Recommendation Report for Planning Permission

REF NO: BR/76/19/PL

LOCATION: Alloways
33 Shelley Road
Bognor Regis
PO21 2SN

PROPOSAL: Conversion of existing house into 2 No. 3 bed semi detached properties.

Proposed Conversion Proposed Plans Planning
Date March 2019
Scale 1:50

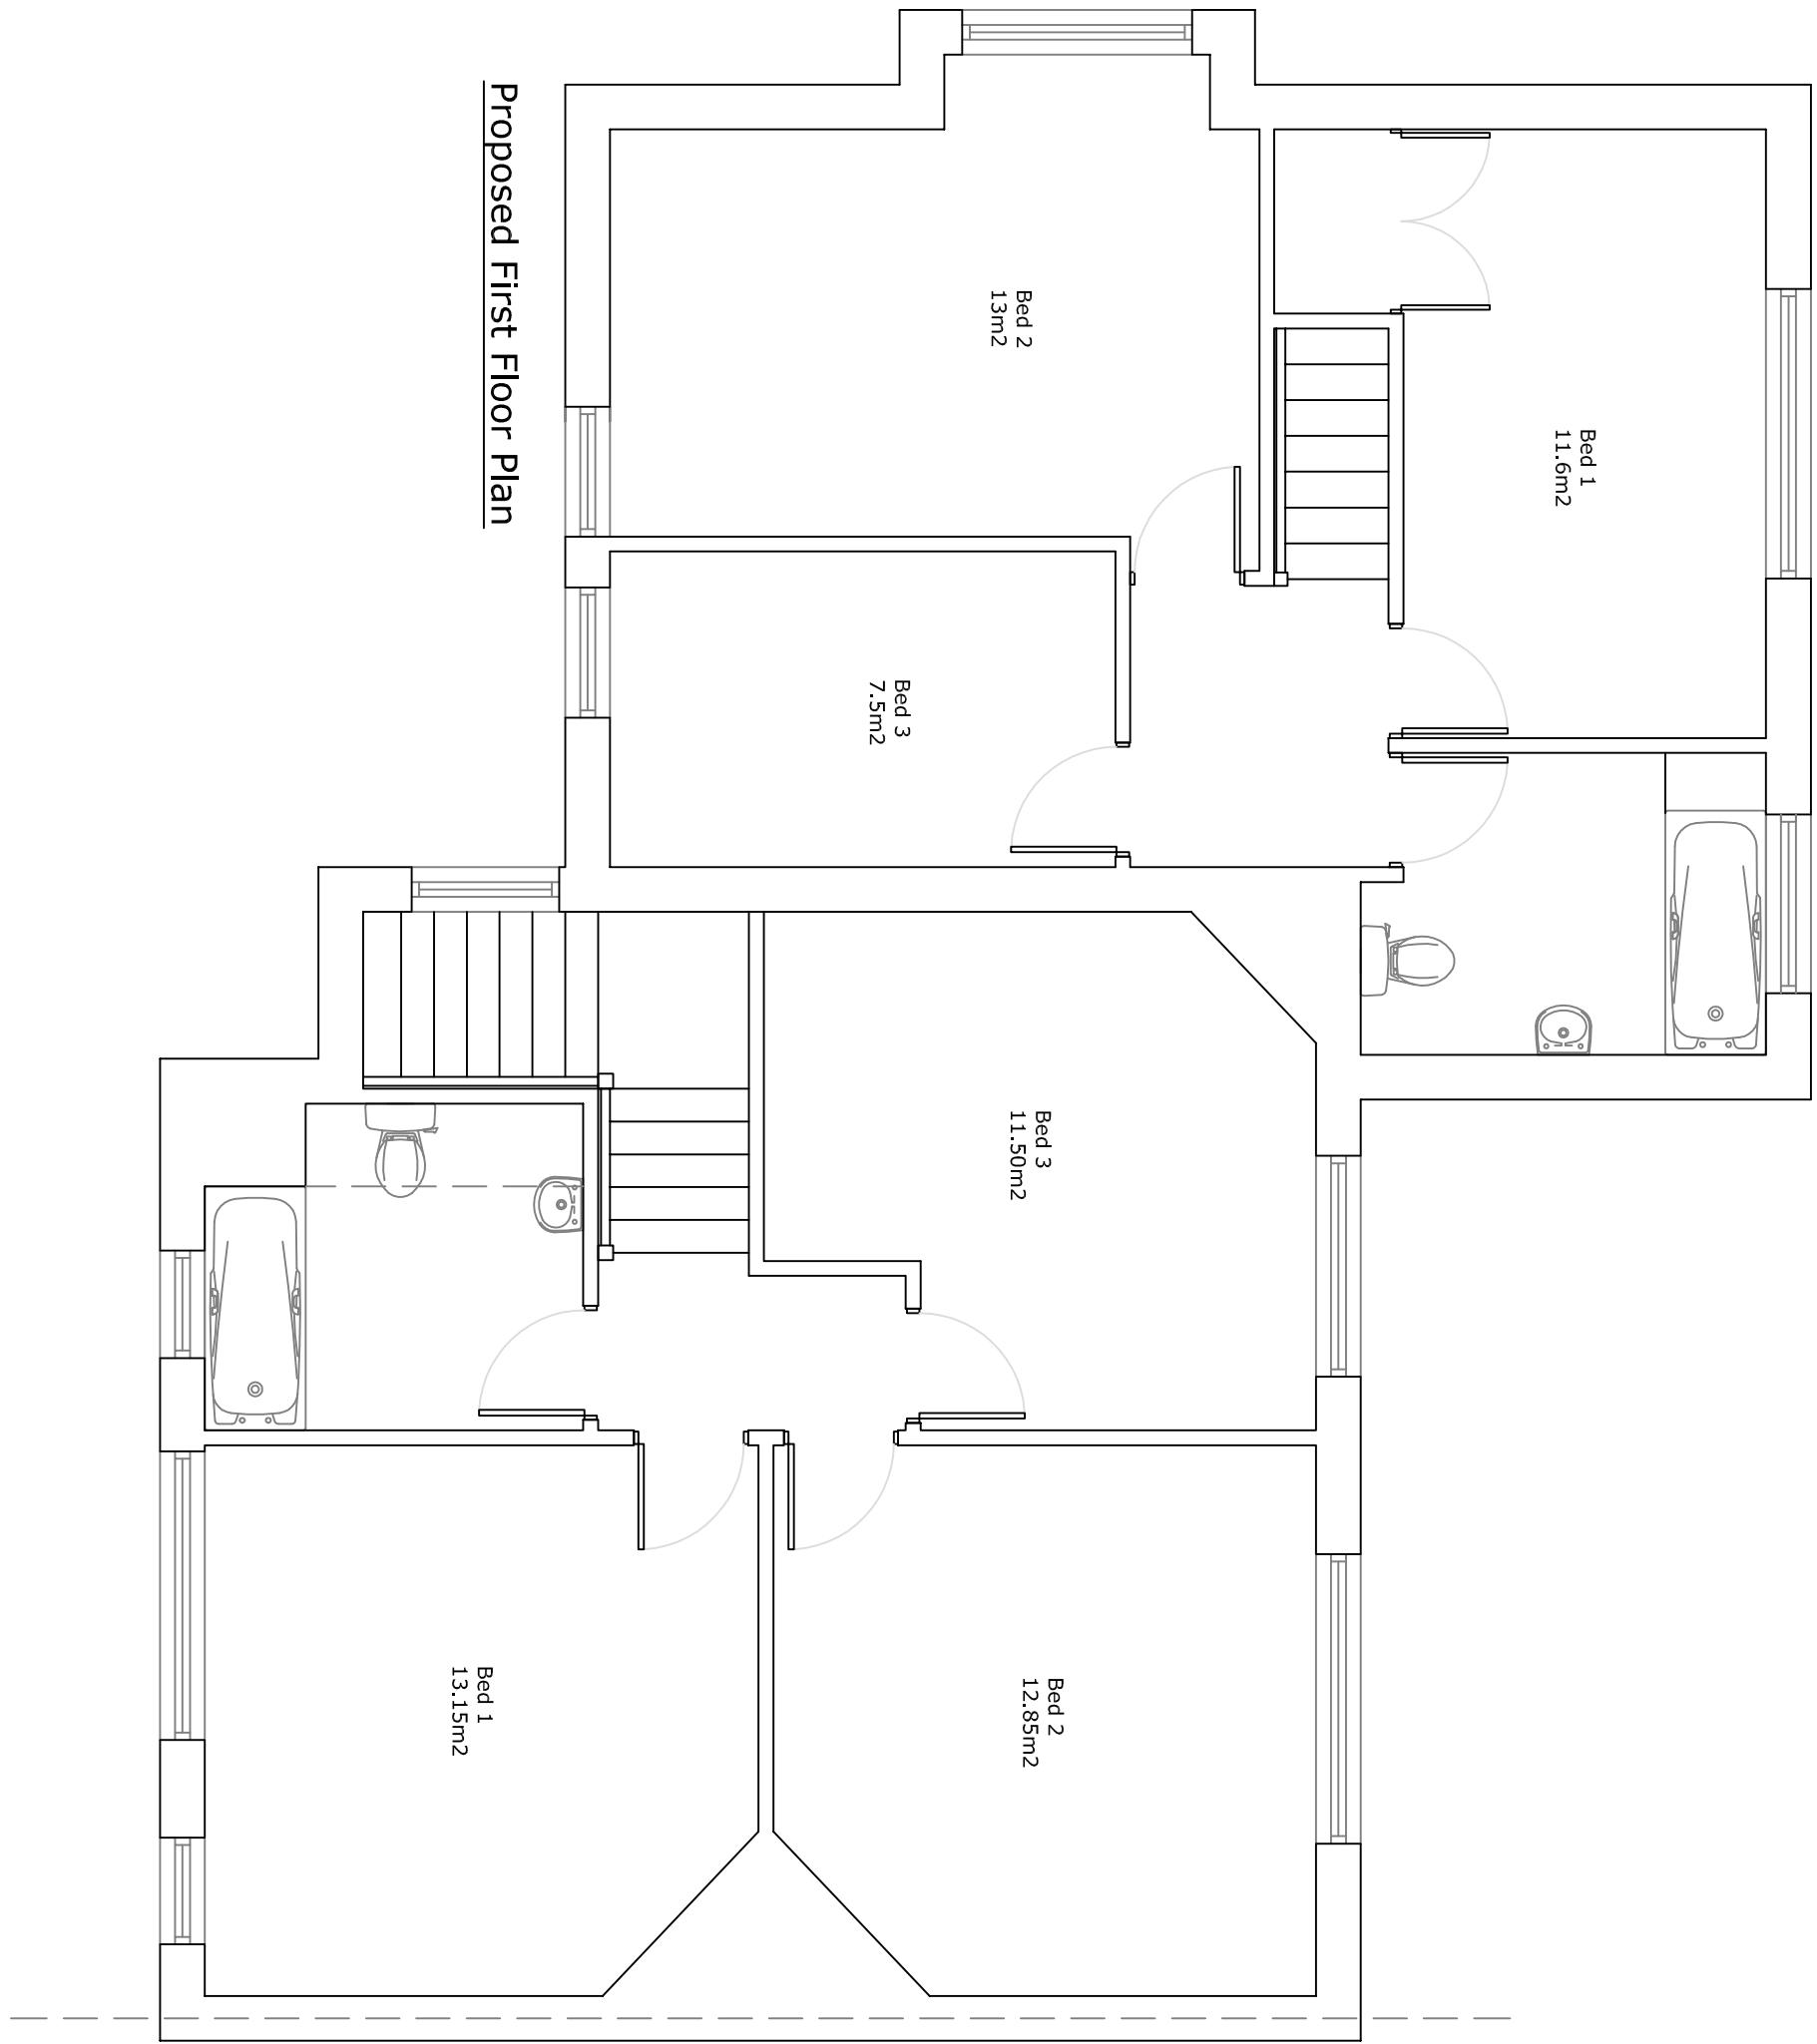
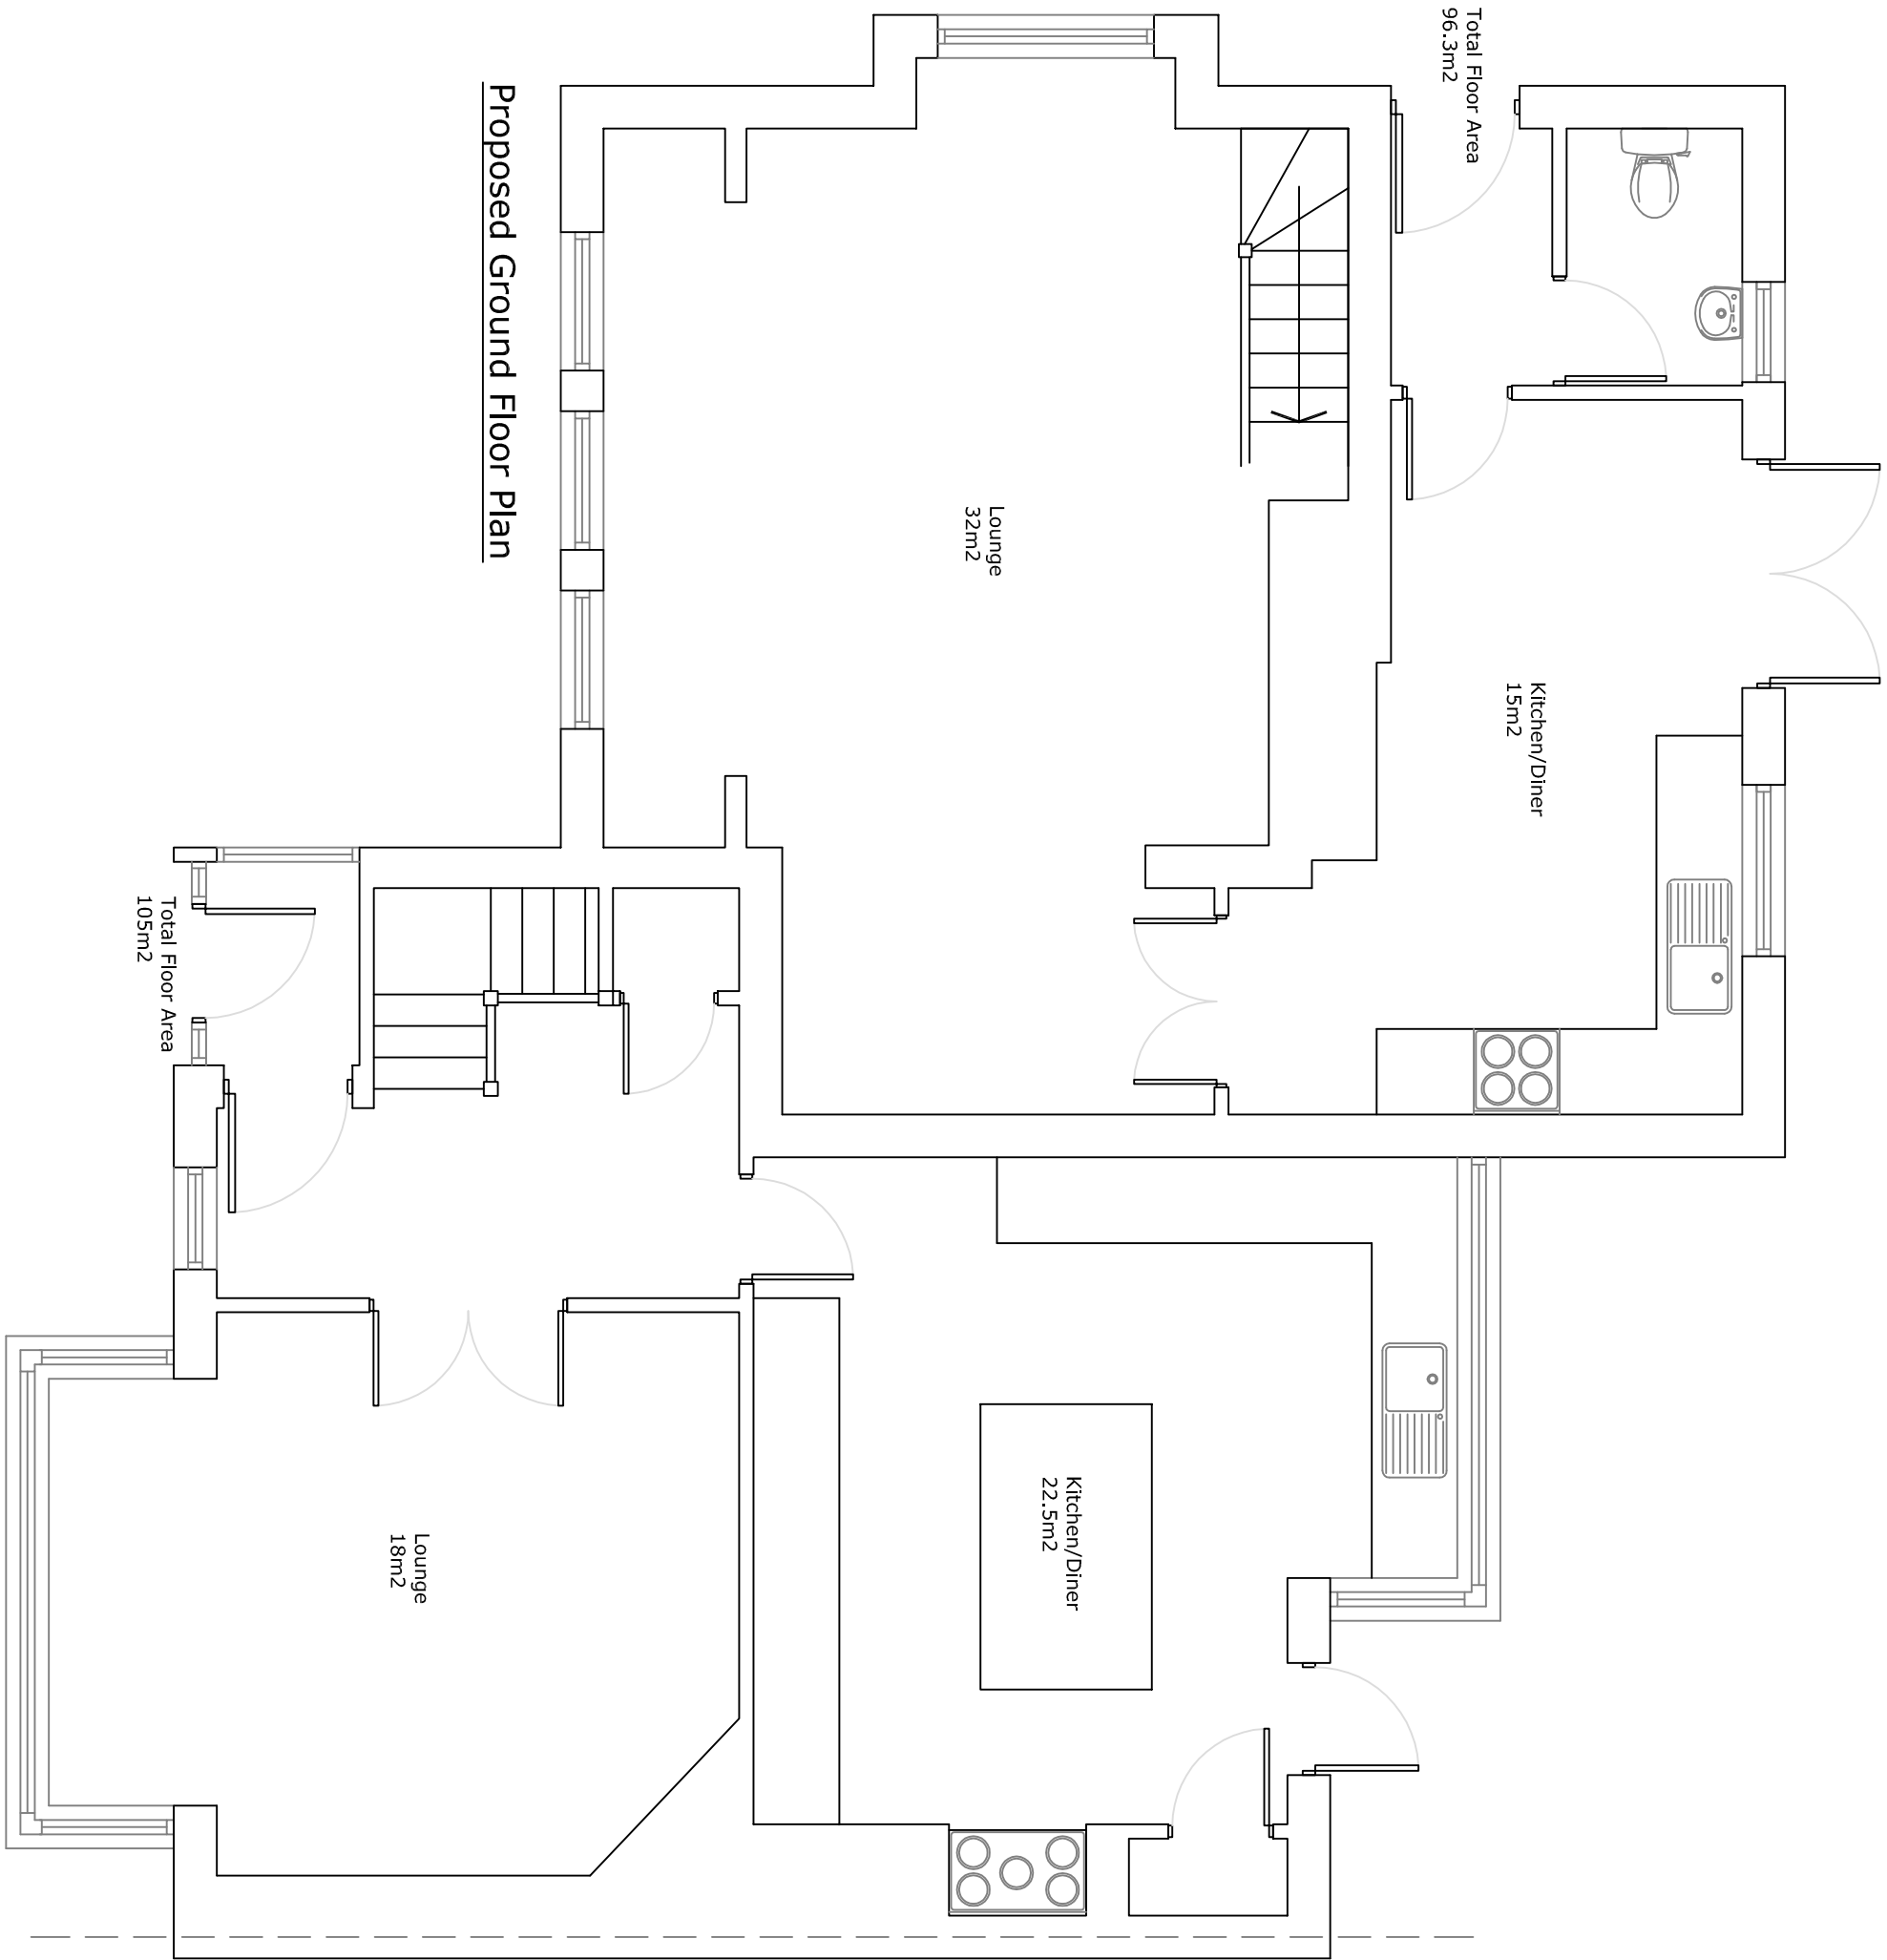
While some loss of light would occur to the kitchen at number 31 as a result of the first floor extension, it is considered that as the depth of the existing rear extension would only be increased by approximately 0.18 of a metre, any additional loss of light would be limited. loss of light to kitchens is not considered to be a reason for refusal as they are not considered to be habitable rooms.

From an assesment of the Technical Housing Standards (Nationally Described Space Standard) Officers consider that bedroom 3 of the proposed end of terrace dwelling would have an internal floor space of 6.91 metres squared and a width of 2.09 metres wide. Therefore Bedroom 3 would not be considered to comply with the Technical Housing Standards (Nationally Described Space Standard) and can not be considered to be a single bedroom. However, it is considered that the other bedrooms, of the proposed end of terrace dwelling, would comply with the internal space standards and would be considered 1 single bedroom and 1 double. Officers consider that the dwelling would have a gross internal floor area of approximately 93.8 metres squared. It is therefore considered that the dwelling would comply with the Technical Housing Standards (Nationally Described Space Standard) for a 2 bed (1 single and 1 double) 3 bed space (person) dwelling

Since the above assesment, regarding internal space standards, the applicant/agent has confirmed that:

'I have drawn a poly line around each room internally on AutoCAD which then calculates the measurements using the list control, giving me the measurements specified, all of which conform to the national government space standard.'

Therefore Officers consider that the proposal would broadly comply with the Technical Housing Standards (Nationally Described Space Standard).
